Our ref: Residential Flat Building at 64-66 Lavender St & 3-7 Middlemiss St, Lavender Bay (SSD-86797708)

Subject: Request for Additional Information

The exhibition of the development application and environmental impact statement (EIS) for the Residential Flat Building at 64-66 Lavender St & 3-7 Middlemiss St, Lavender Bay (SSD-86797708) ended on 24 June 2026.

Key Move 6: Dynamic Skyline

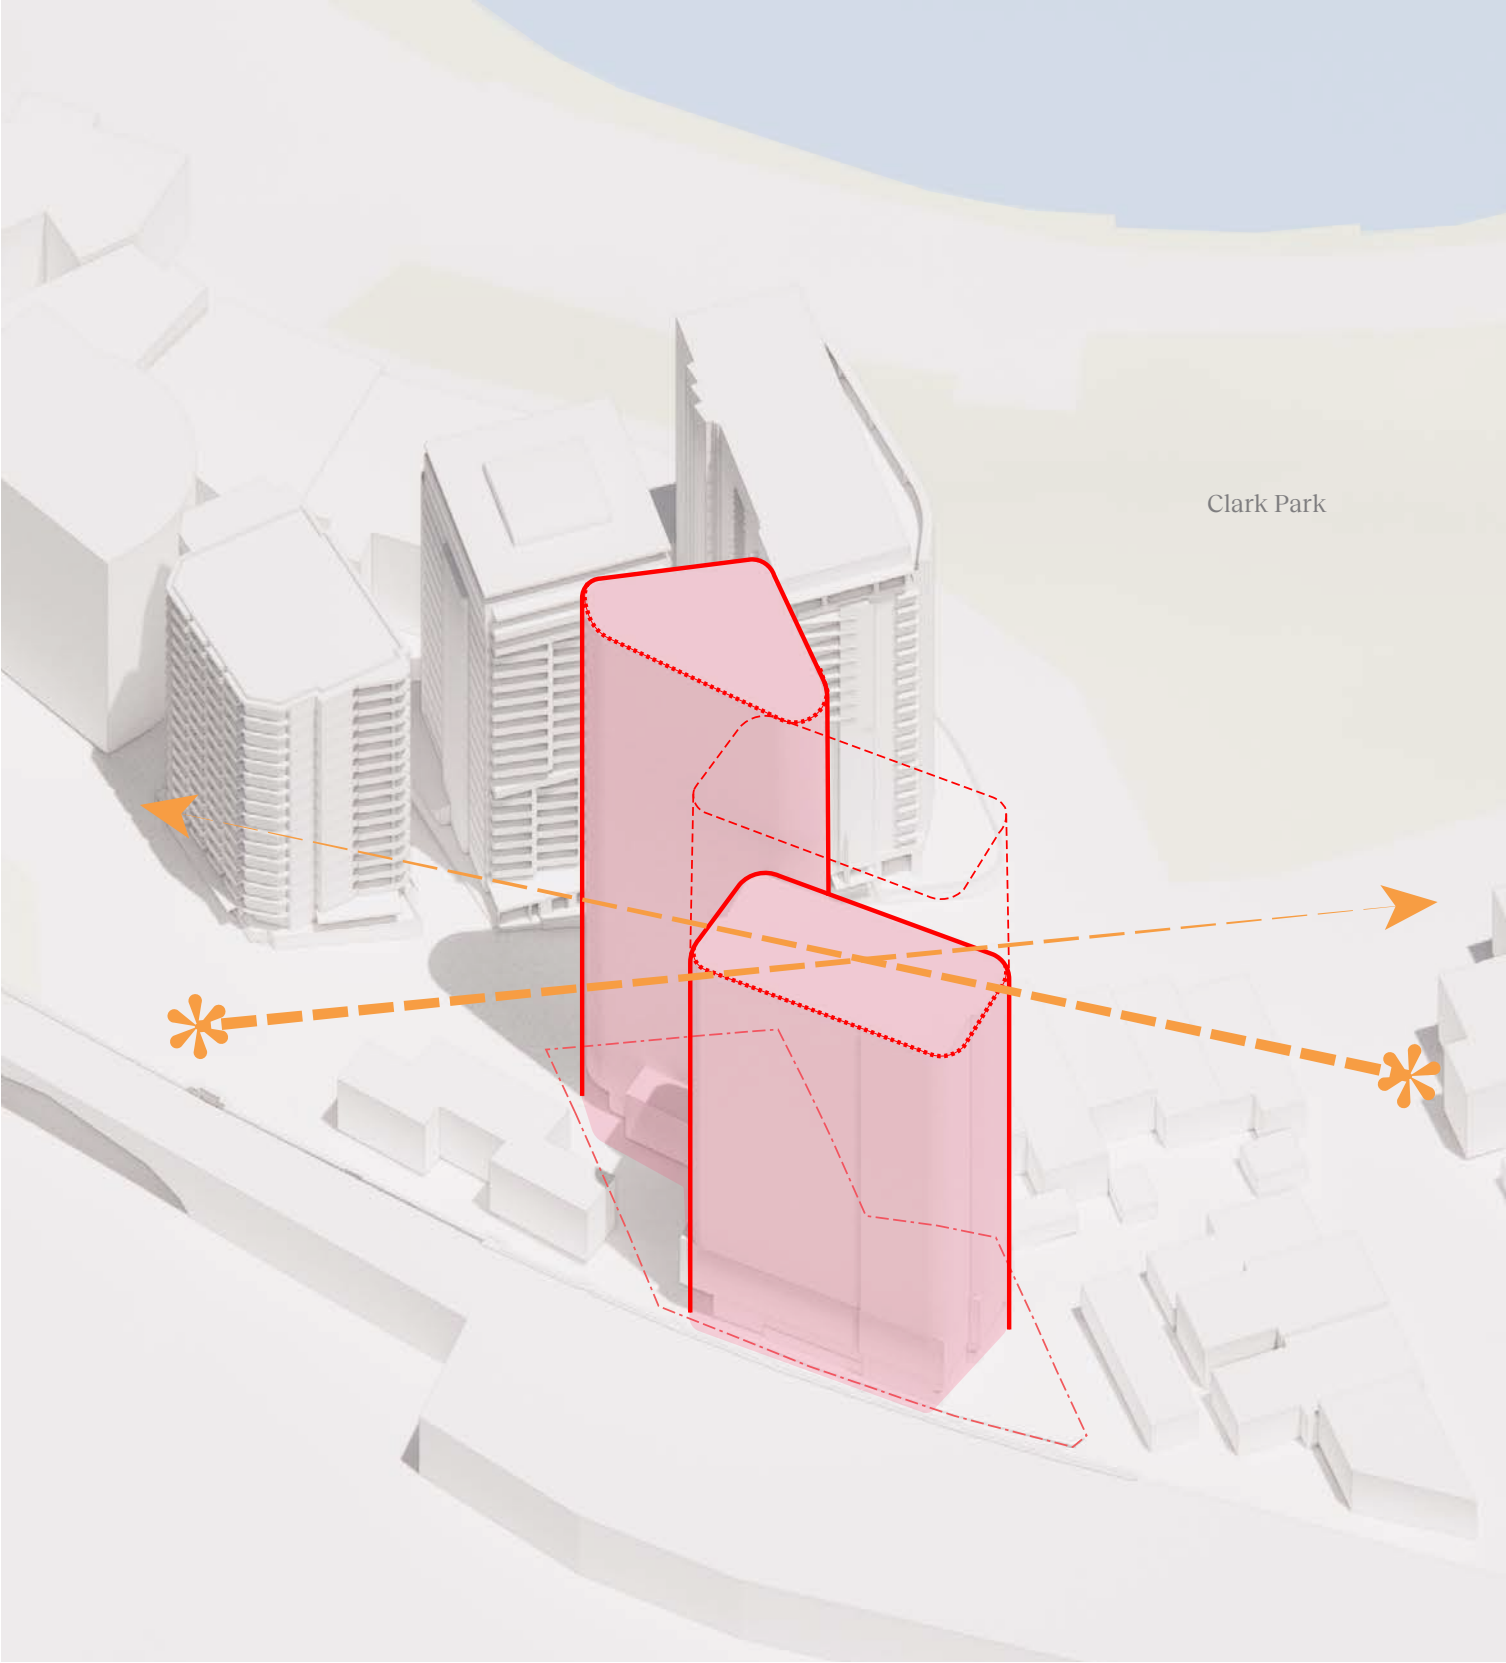
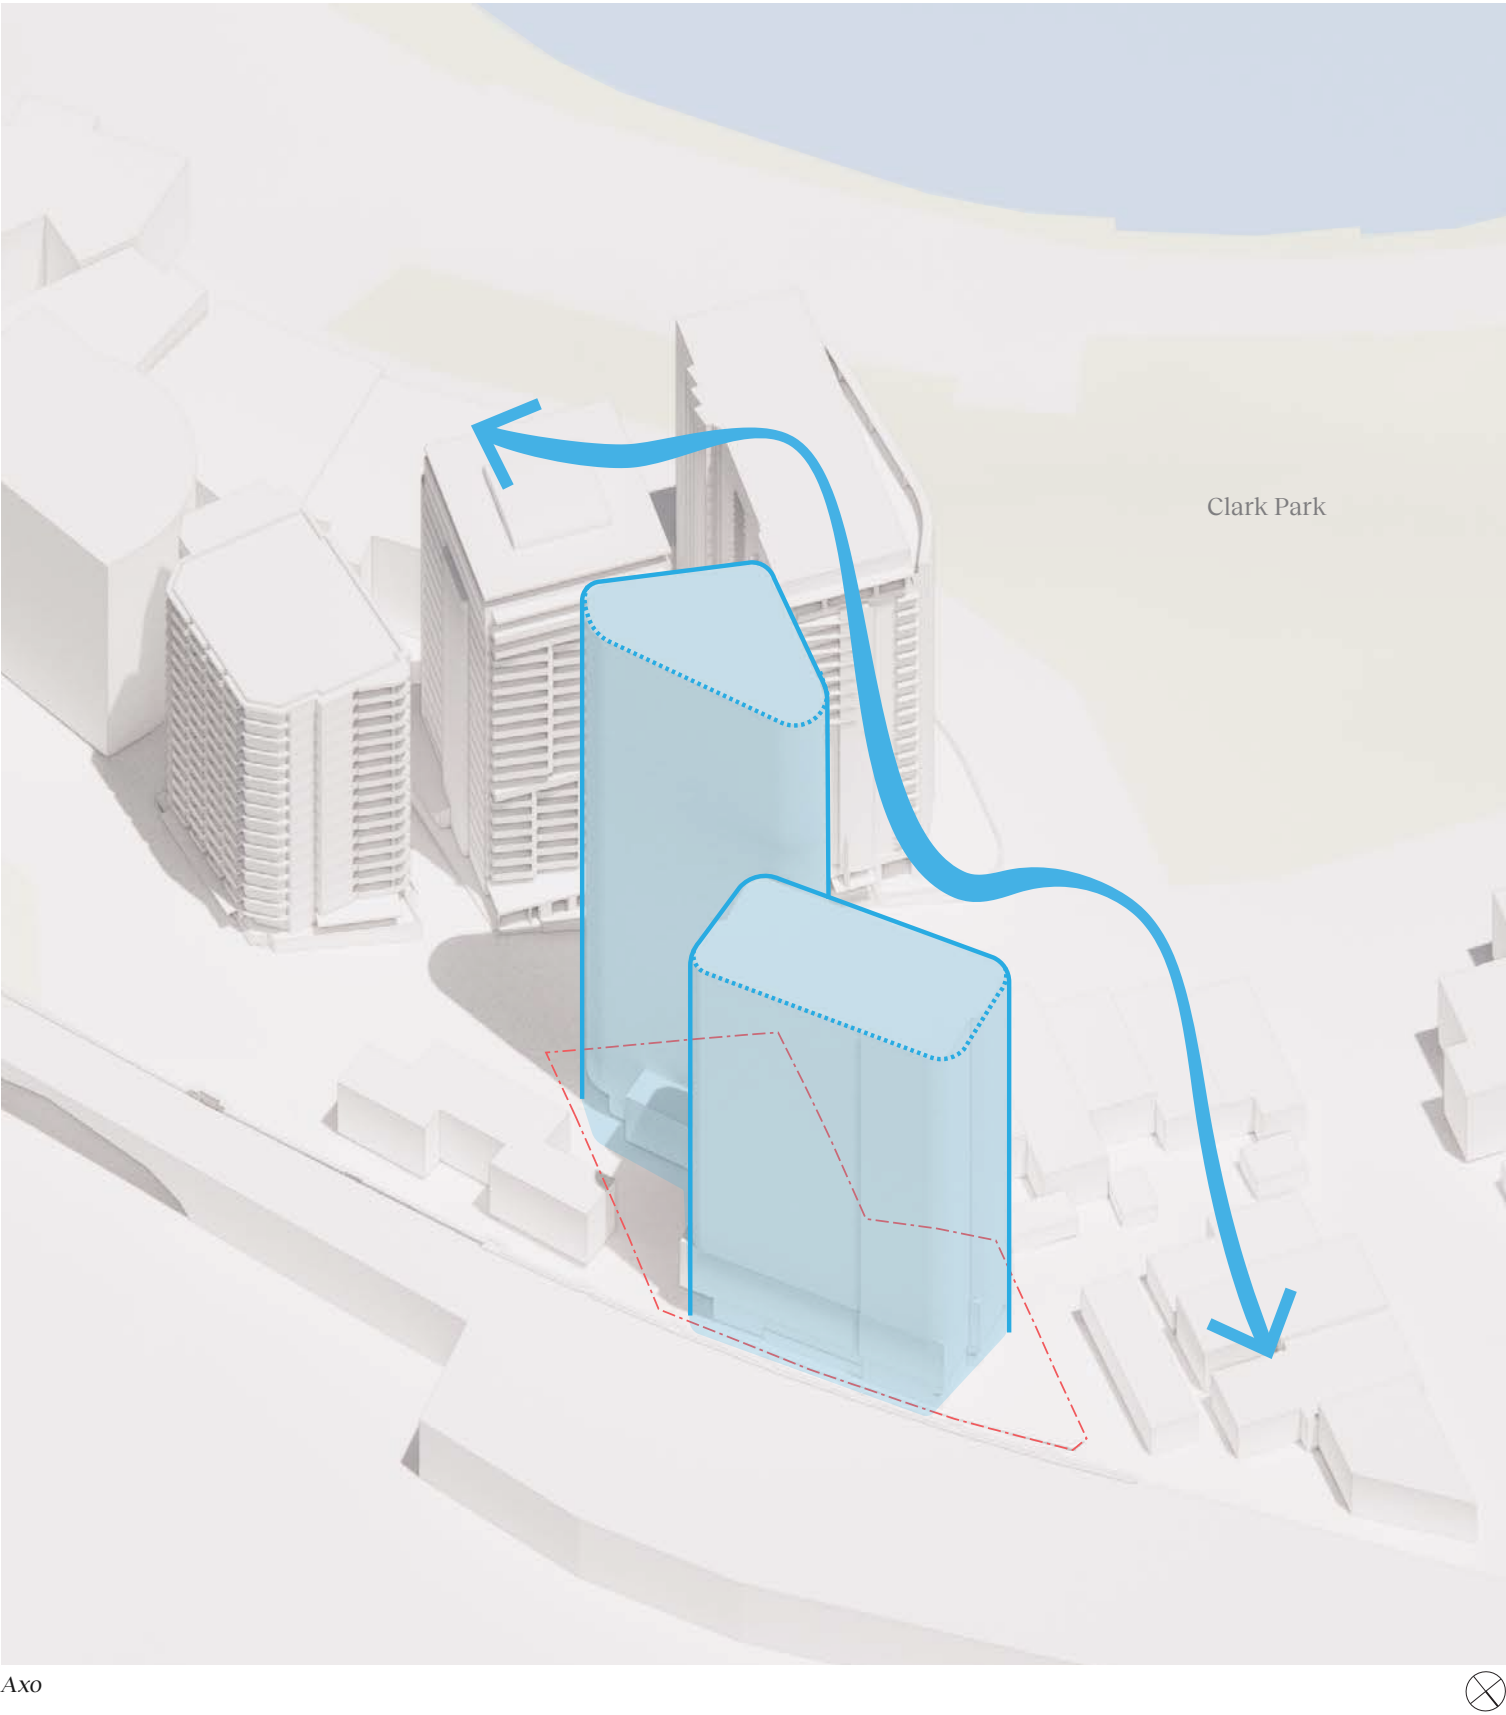
- b) The two tower form, in particular the northern tower (Tower A) is not supported, as it does not allow for sufficient building separation and boundary setbacks.

- d) The proposed 6m tower separation is inadequate and results in significant adverse built form, amenity and visual impacts to future residents and the surrounding locality. The Apartment Design Guide (ADG) would typically require building separation distances between 18m-24m for two towers of this scale.

- The Department recommends that alternative massing options are tested that respond to the issues raised in this letter and result in a single built form with a positive address to Lavender Street. A meeting should be arranged with the Department to discuss alternative design options more appropriate for the context.

DATE: 2026-03-16
JOB NO: P0062138
DWG NO: VP_4C
REV: -

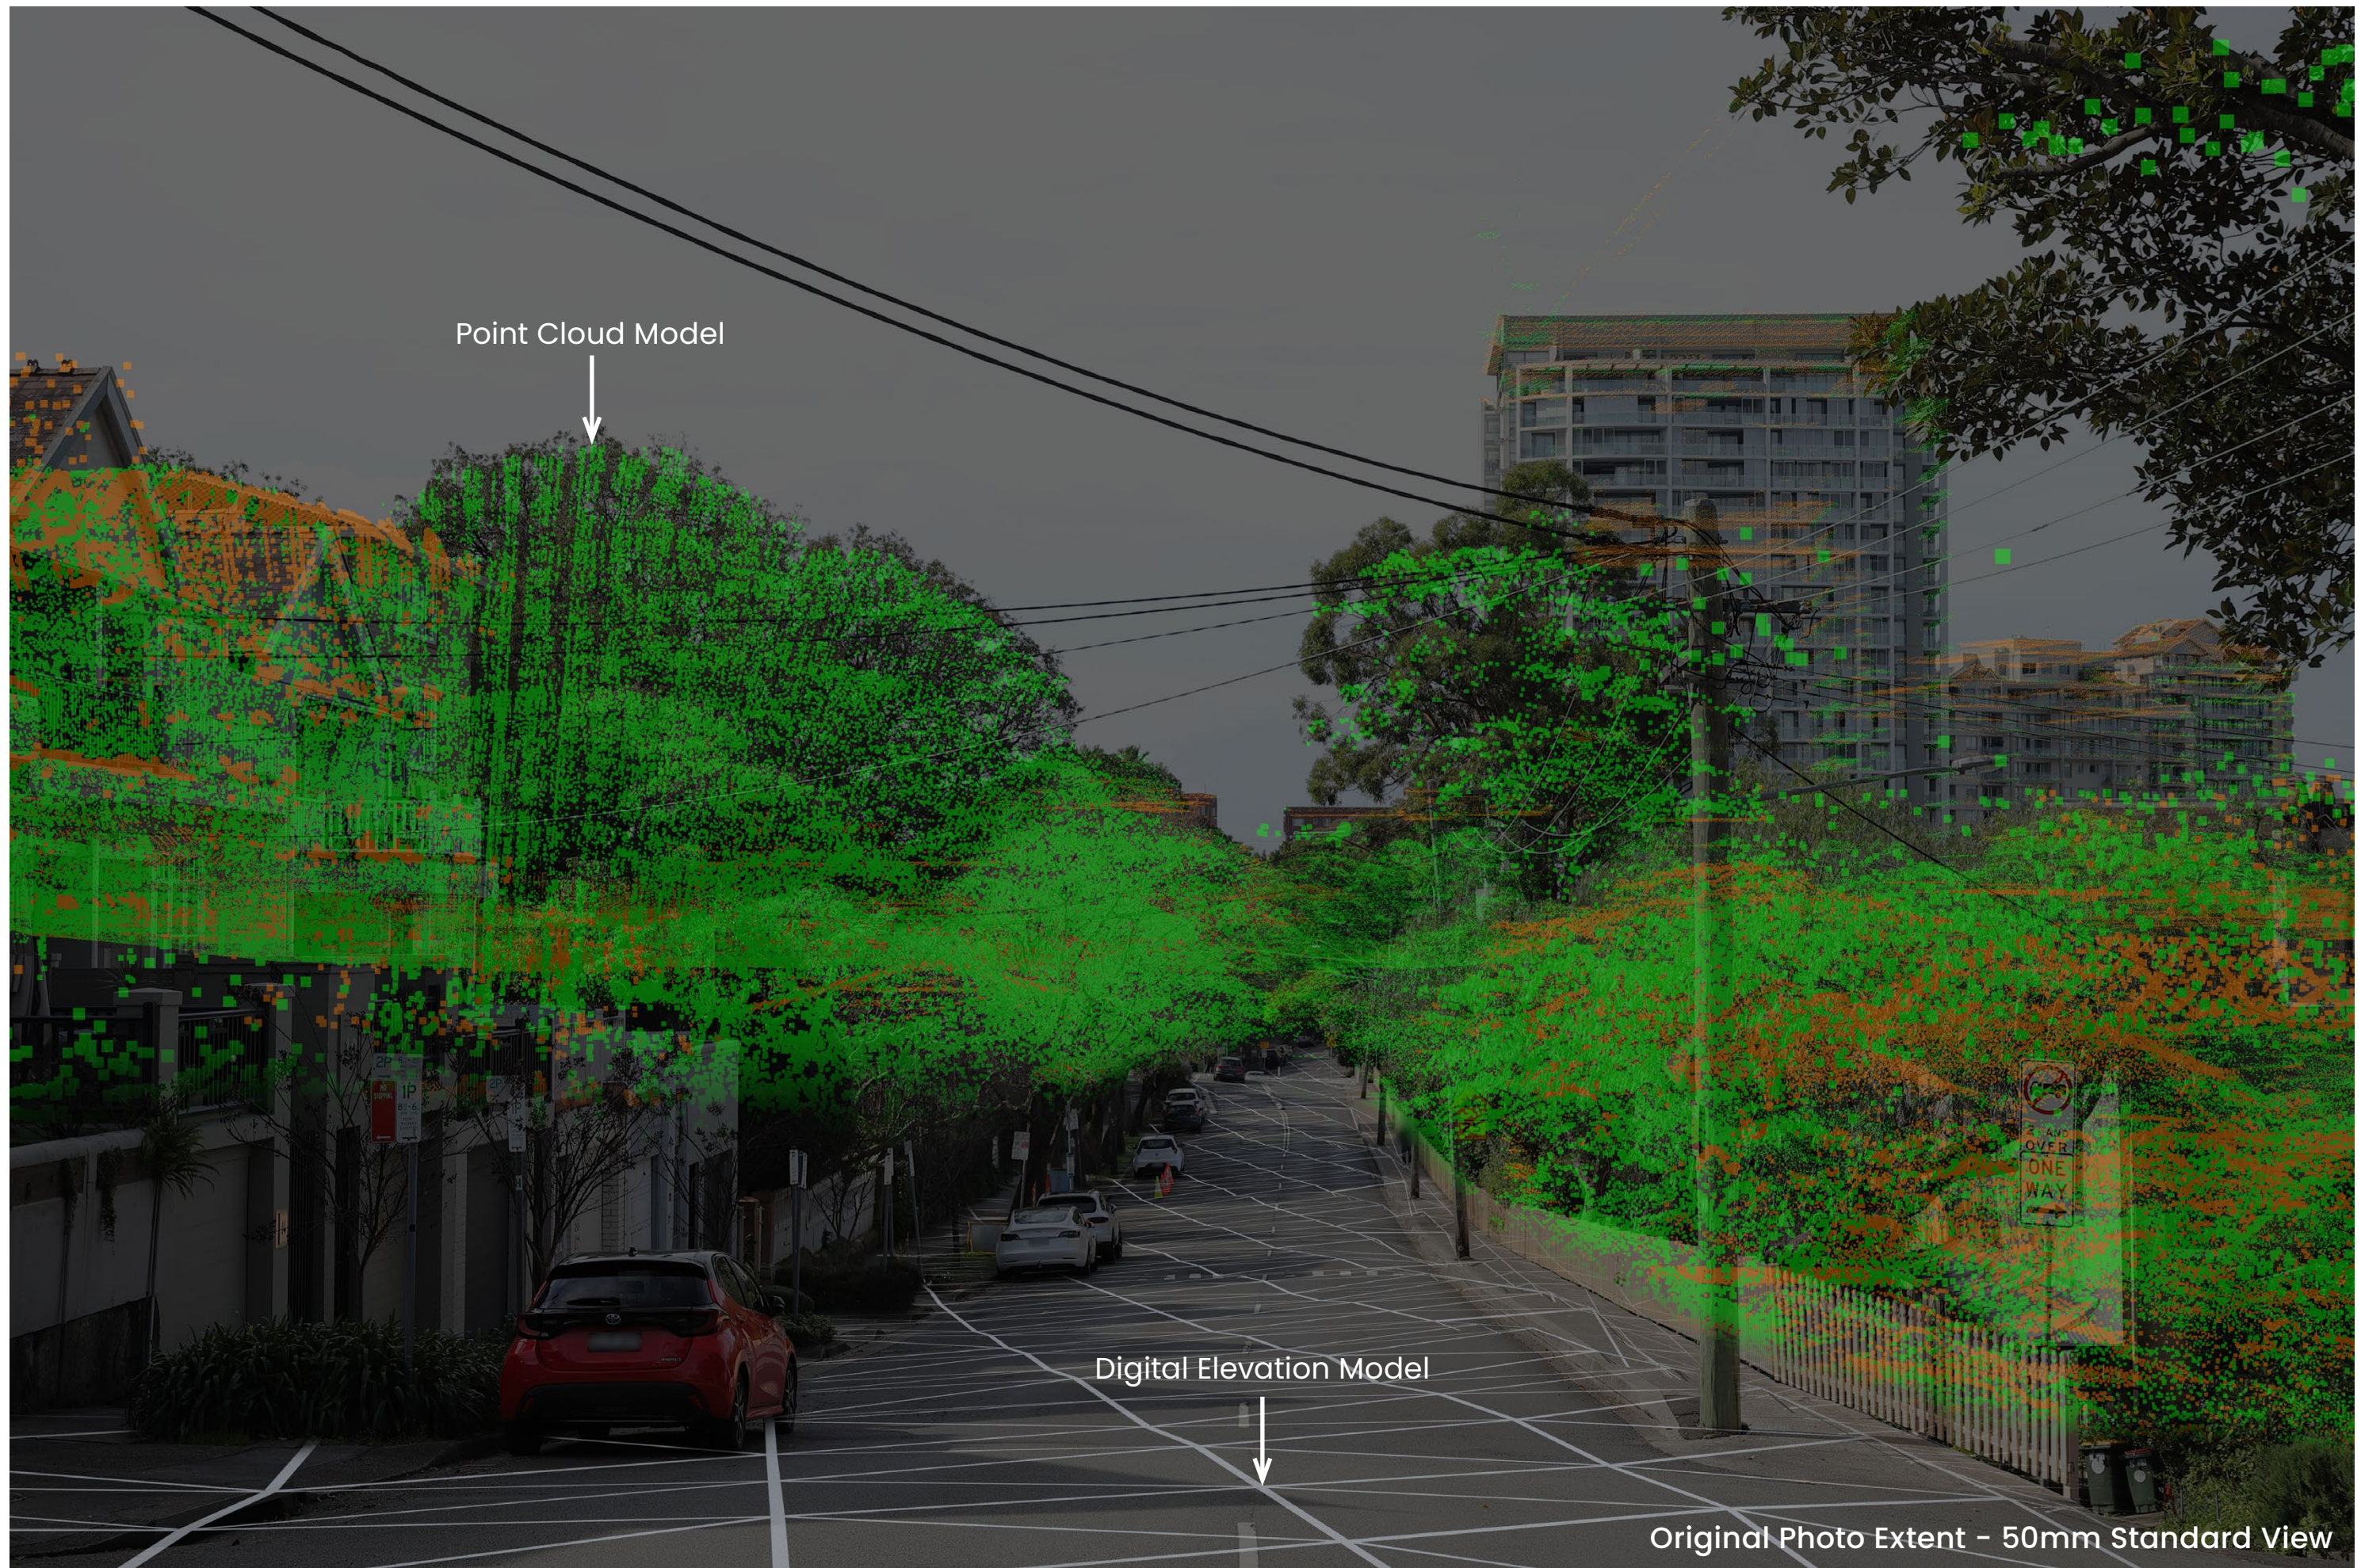
- a) Based on the information provided, the proposal is considered to introduce a visually overbearing element on the area due to its abrupt and insufficiently mitigated transition in height, scale and lack of building separation. The proposal will add a disproportionately bulky element to the skyline and character of the area that is not considered to be in harmony with the low scale setting of Lavender Bay when viewed from the streetscapes to the west.

- b) The visual and view impact assessment does not contain sufficient analysis, based on evidence, to determine the impacts on other sensitive public and private view points in the surrounding area, including:

- Reconsider the built form (as addressed above in the letter) to further consider sensitive views obtained from the surrounding area
- Provide analysis of additional viewpoints obtained from the sensitive vantage points noted above
